MID-VALLEY DRAINAGE MANAGEMENT PLAN

ADDENDUM 1: July 17, 2012

SEC PROJECT NO. 110112

PROPOSED FACILITIES
F2, F10 & F11
FIGURE E3

**PROPOSED FACILITIES
F2, F10 & F11
FIGURE 1**

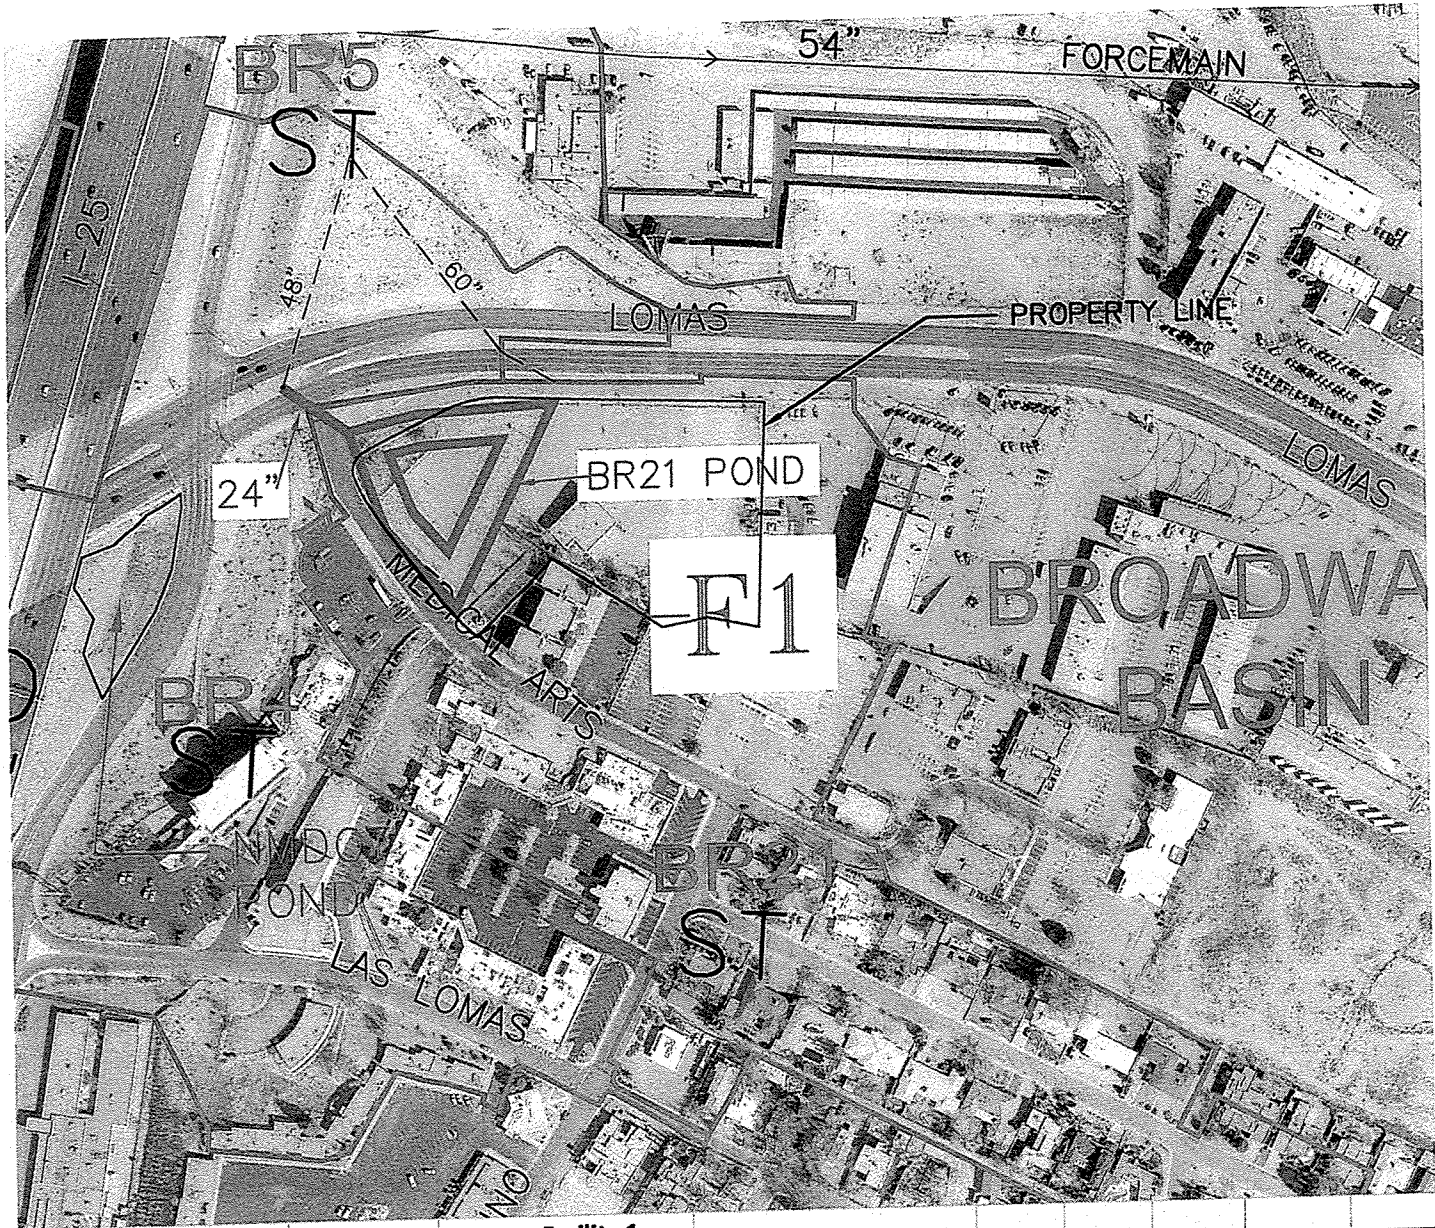
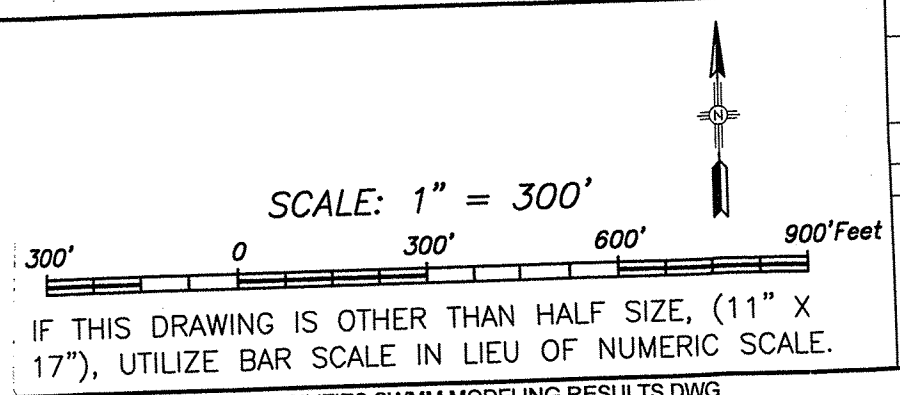
F2.1	\$	1,116,000
F2.2	\$	1,873,000

TOTAL	\$	2,989,000 *
-------	----	-------------
